Re: Southwest Public Safety Center
9631 Amole Mesa Ave SW
30-Day Temporary Certificate of Occupancy
Transportation Development Final Inspection
Architect's Stamp dated 01-04-24 (N09-D015)
Certification dated 09-15-2025
TRANS-2025-00269

Based upon the information provided in your submittal received 09-19-25, Transportation Development has no objection to a 30-day Temporary Certificate of Occupancy based. This letter serves as a "green tag" from Transportation Development for a 30-day Temporary Certificate of Occupancy to be issued by the Building and Safety Division.

CITY OF ALBUQUERQUE CAPITAL IMPLEMENTATION PROGRAM			
SOUTHWEST PUBLIC SAFETY CENTER			
Drawing Title			
TCL			
Design Review Committee	City Engineer Approval	Last Design Update	
		Mo./Day/Yr.	
		Mo./Day/Yr.	
Issue Date:	City Project No.	Sheet	
JANUARY 2024		TCL

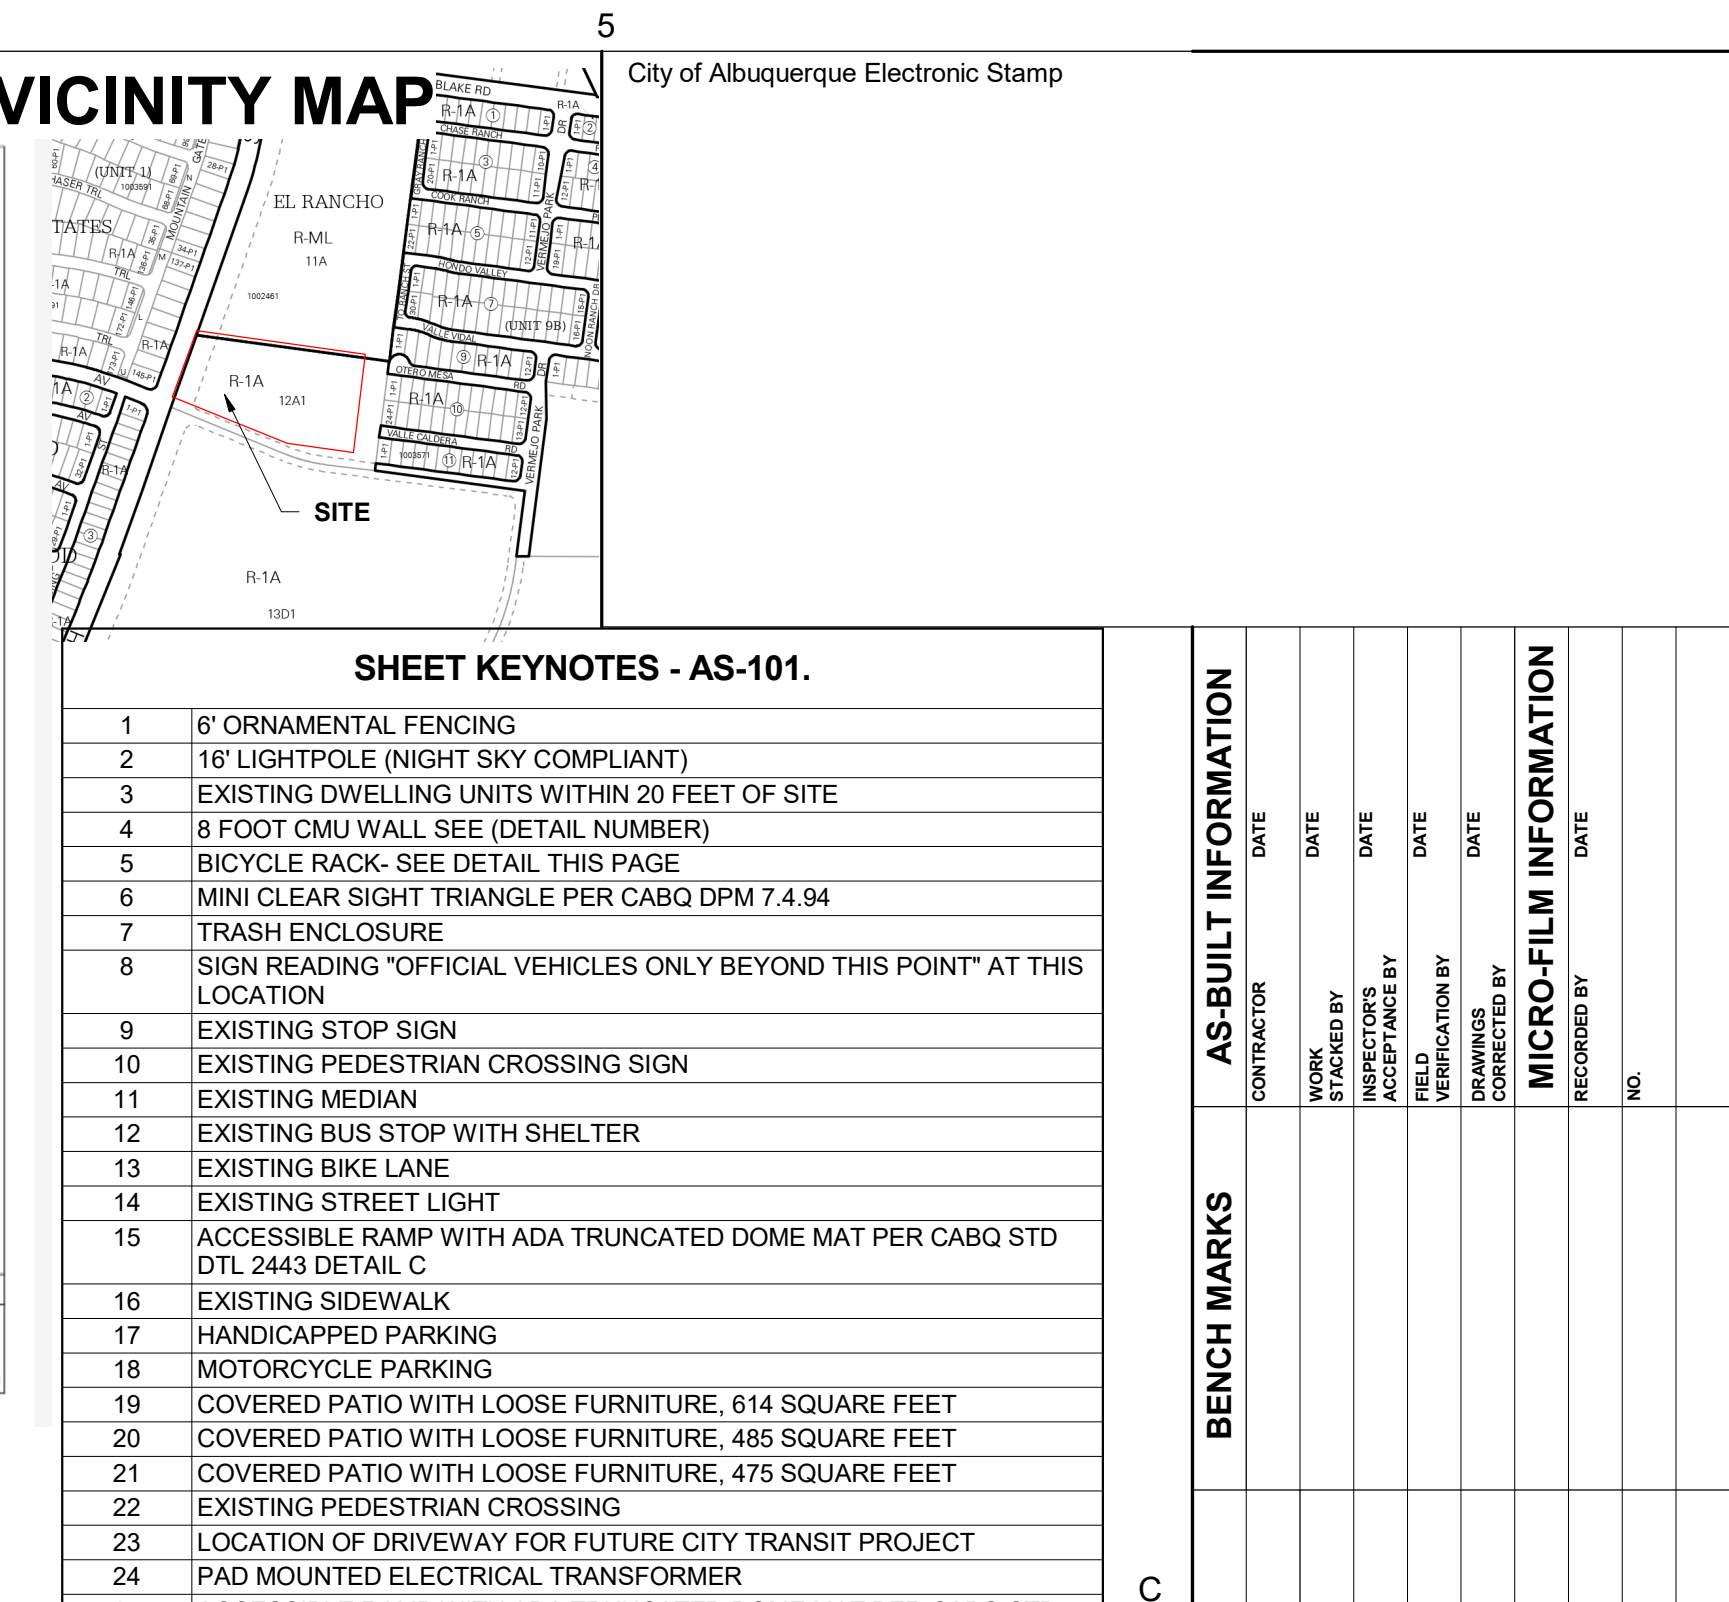
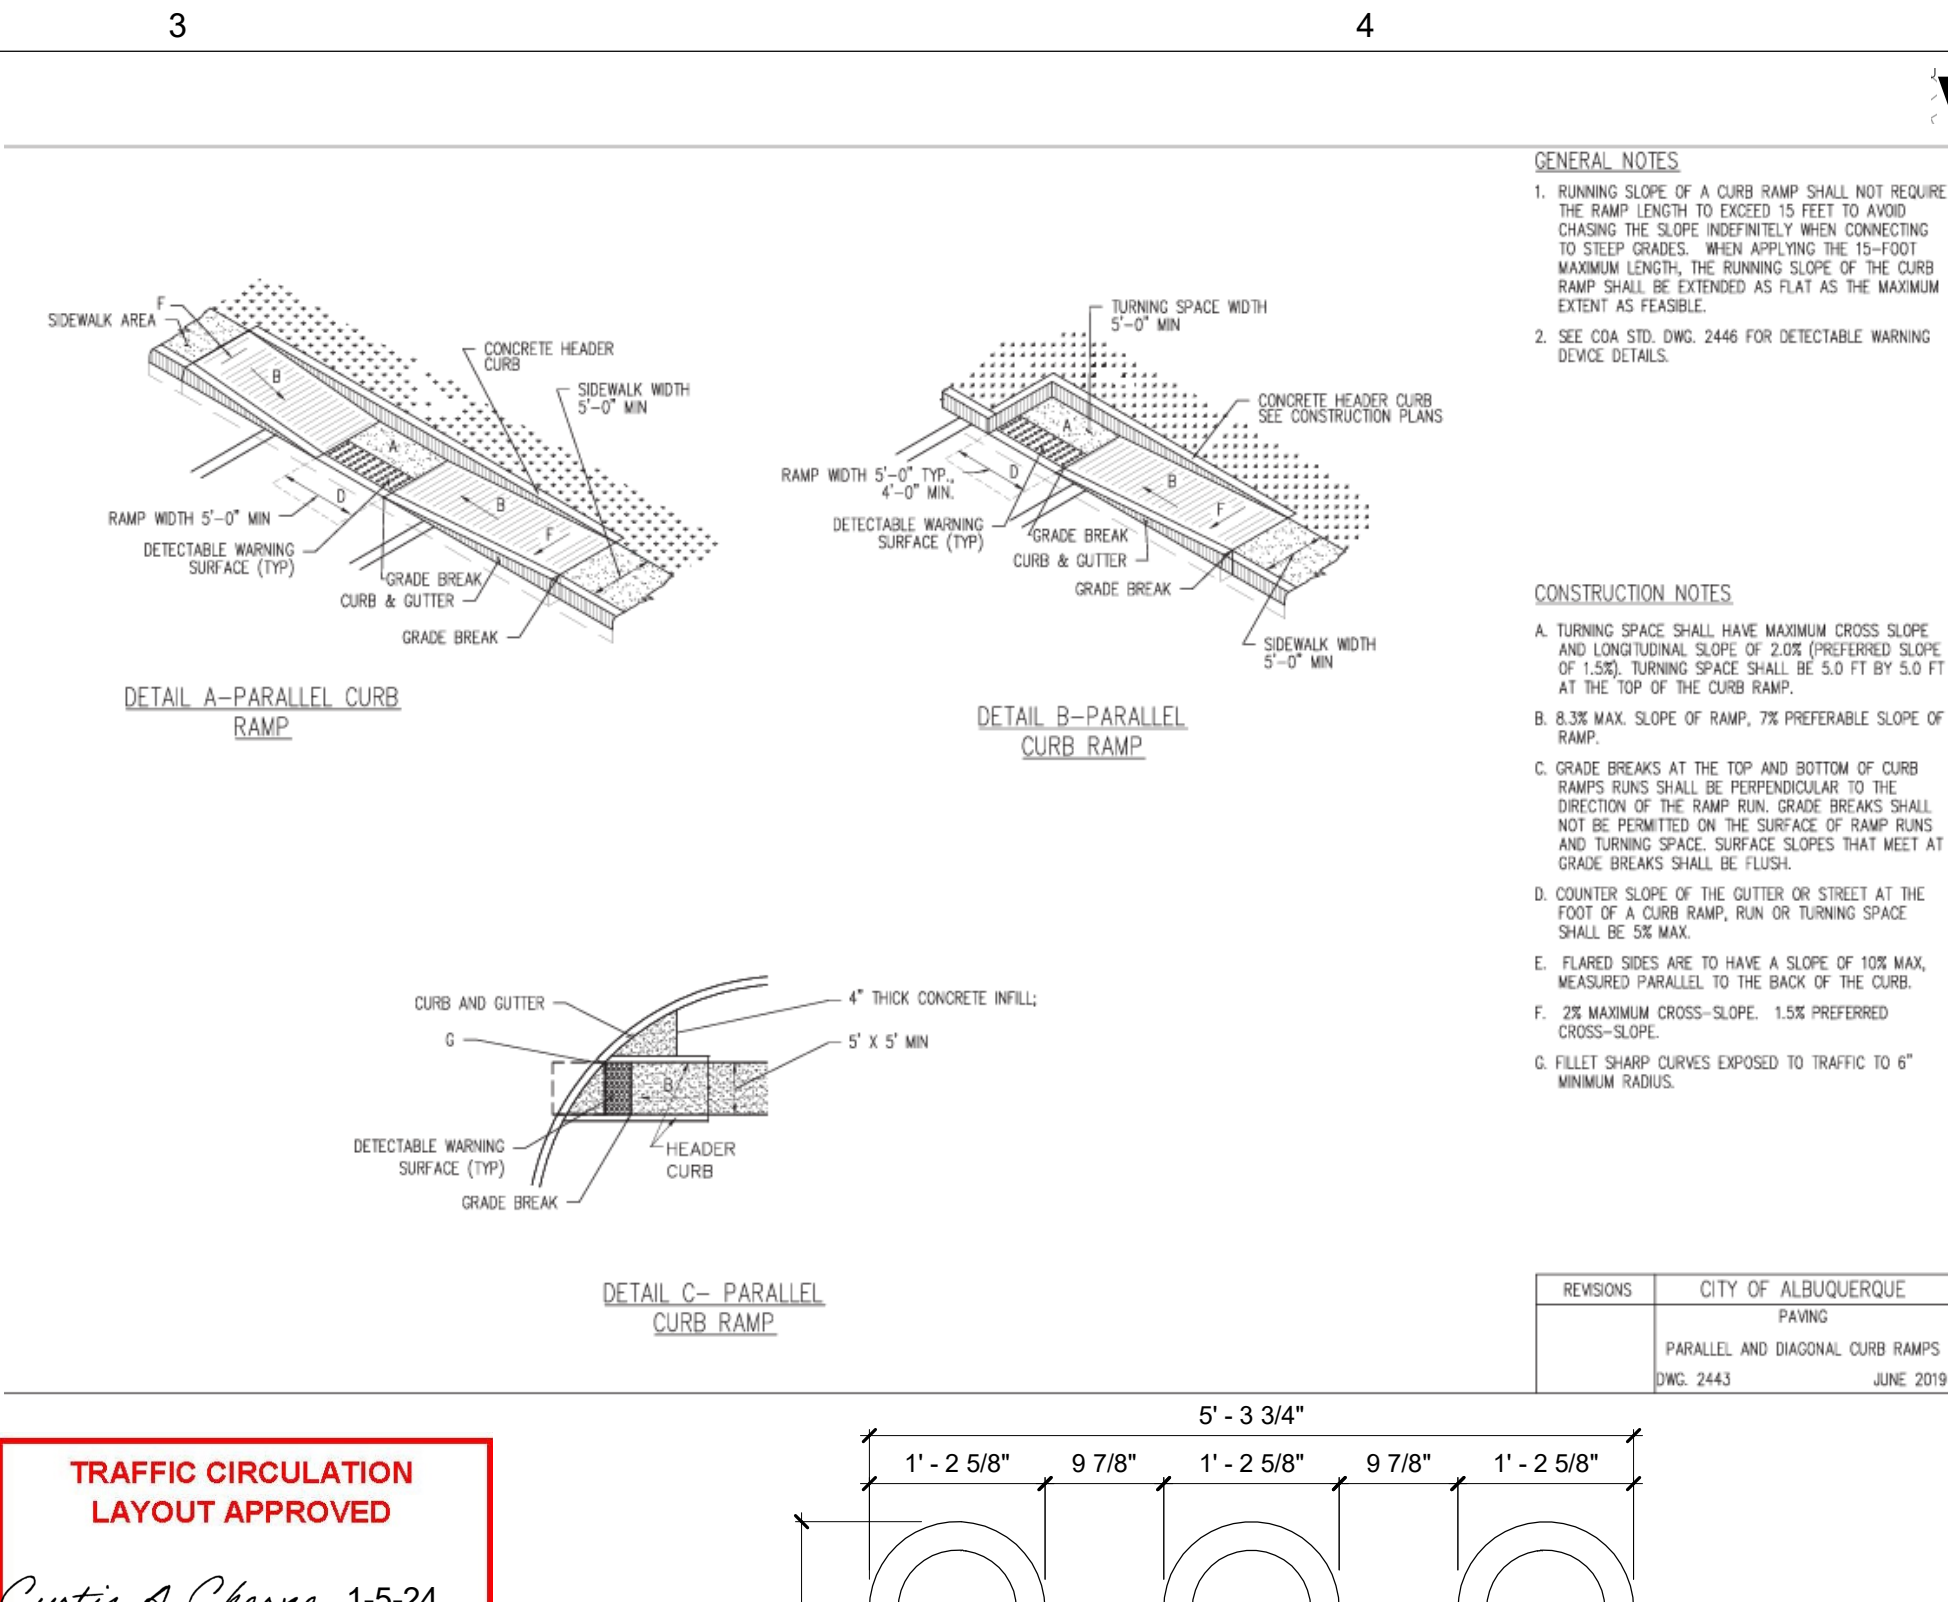
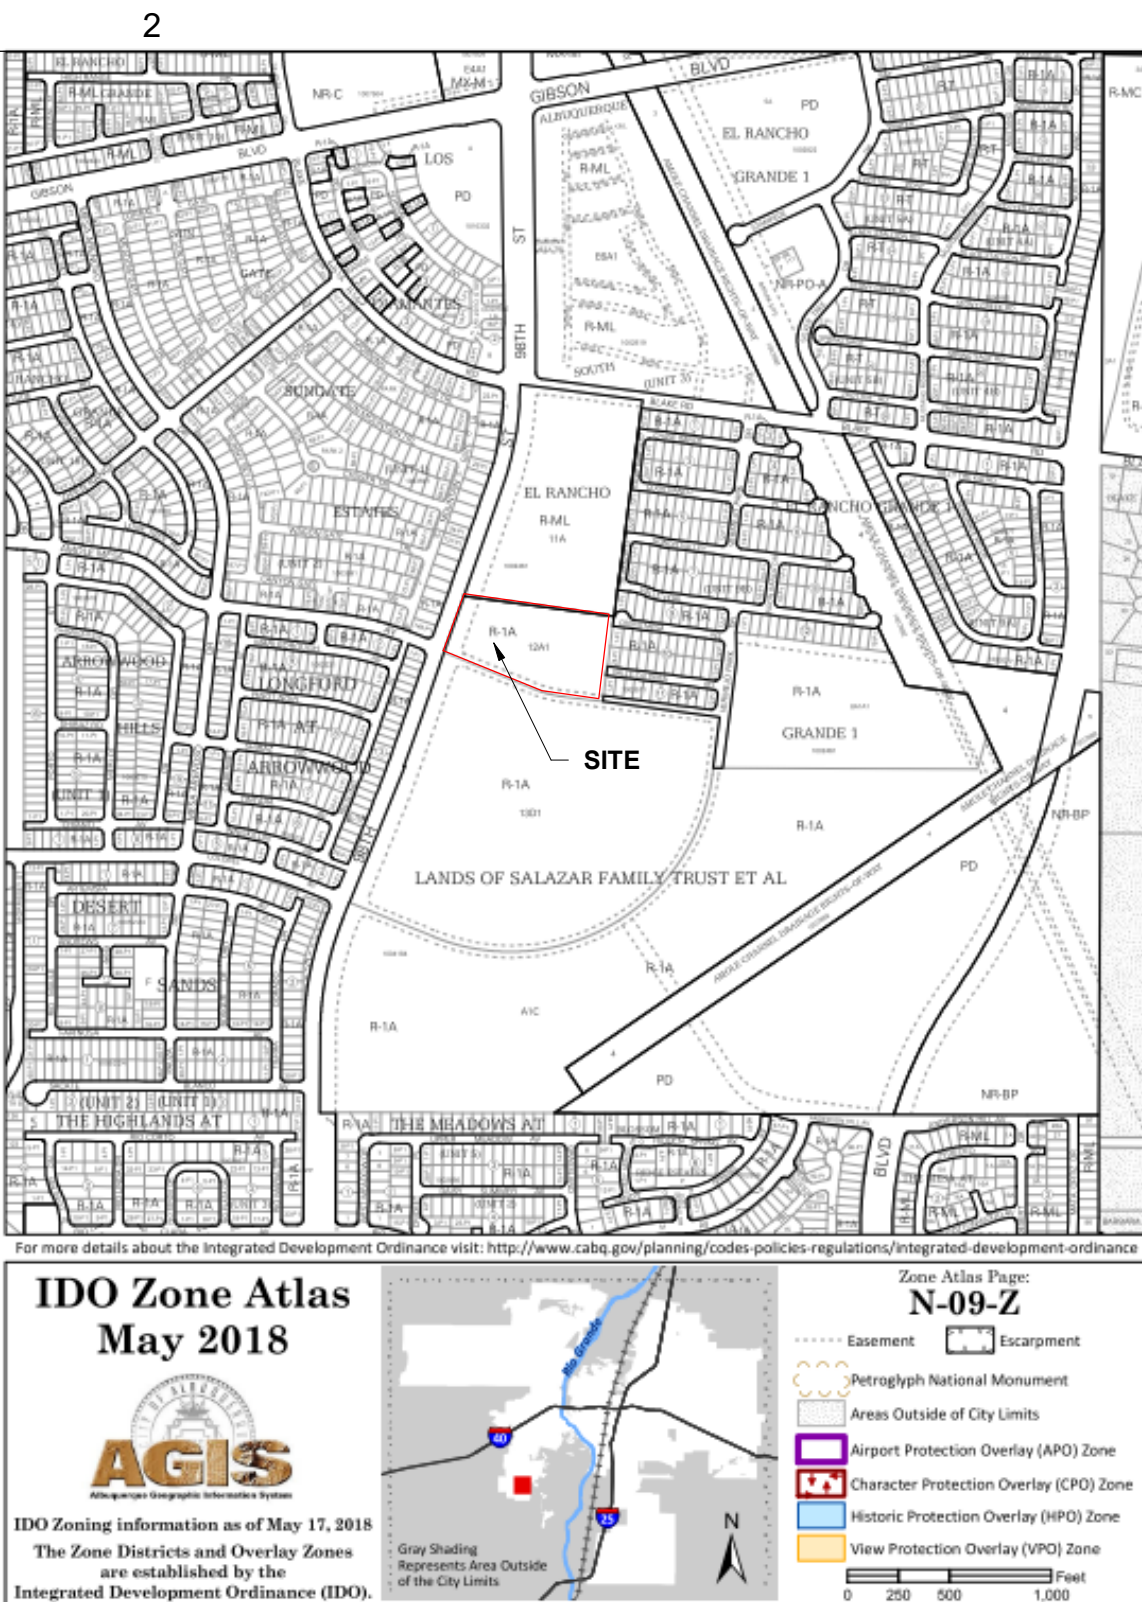
1. A 5 ft. keyway is required for dead-end parking aisles. Please cross-hatched the last two parking stalls on the northeast side and southeast side of the building to prohibit vehicles from parking or stopping to create the 5 ft keyway.

1. Provide the required ADA signage. The ADA accessible parking sign must have the required language per 66-7-352.4C NMSA 1978 **"Violators Are Subject to a Fine and/or Towing."**
2. Anchor down bike rack.
3. Provide copy of the approved work order.
